**POROUS LANDSCAPE DETENTION GRADING
7340 UTAH LANE
EL PASO COUNTY, COLORADO**

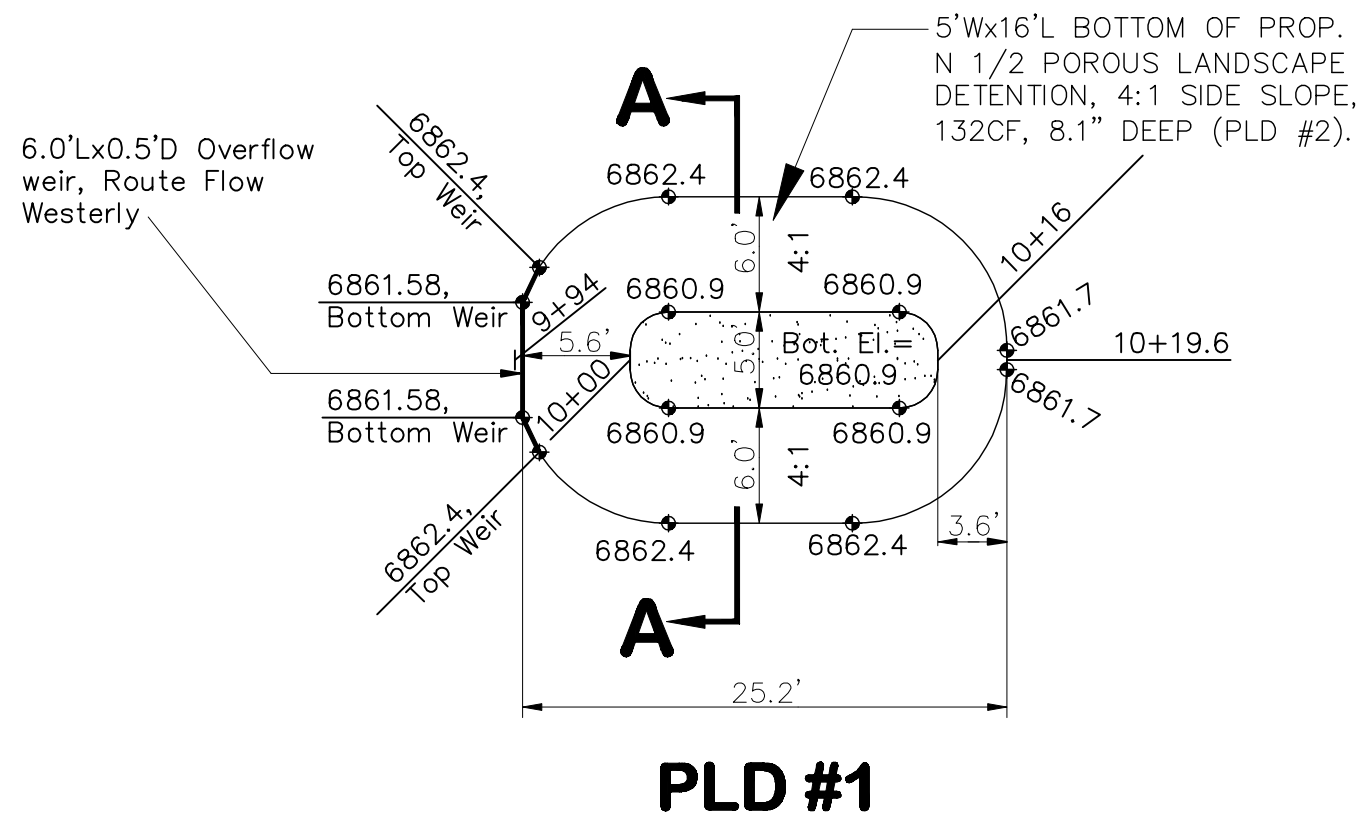
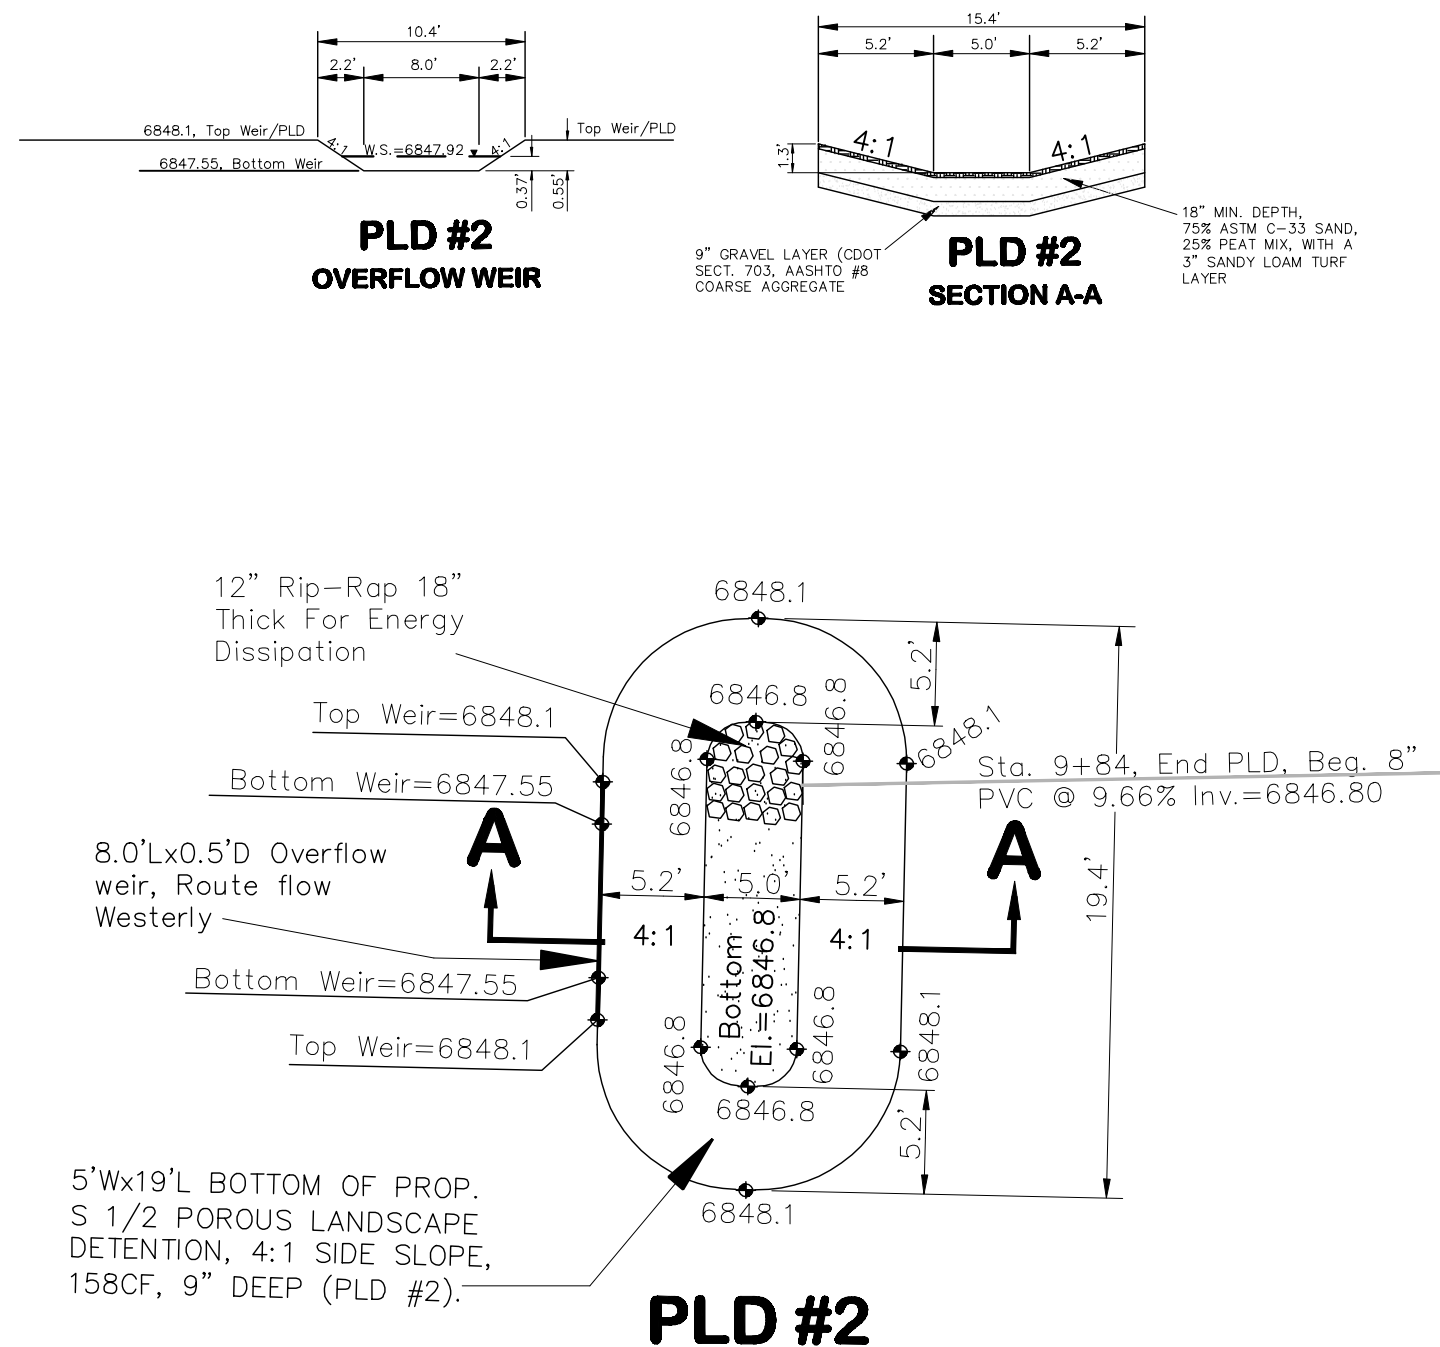
Does the stormwater exit the facility through an outlet structure or through infiltration? Please clarify by showing on these details. Infiltration Discussed in report & on shown Const. Plans

Const. drawings will be separate set These construction details should must be in the construction drawings, not in the drainage report.
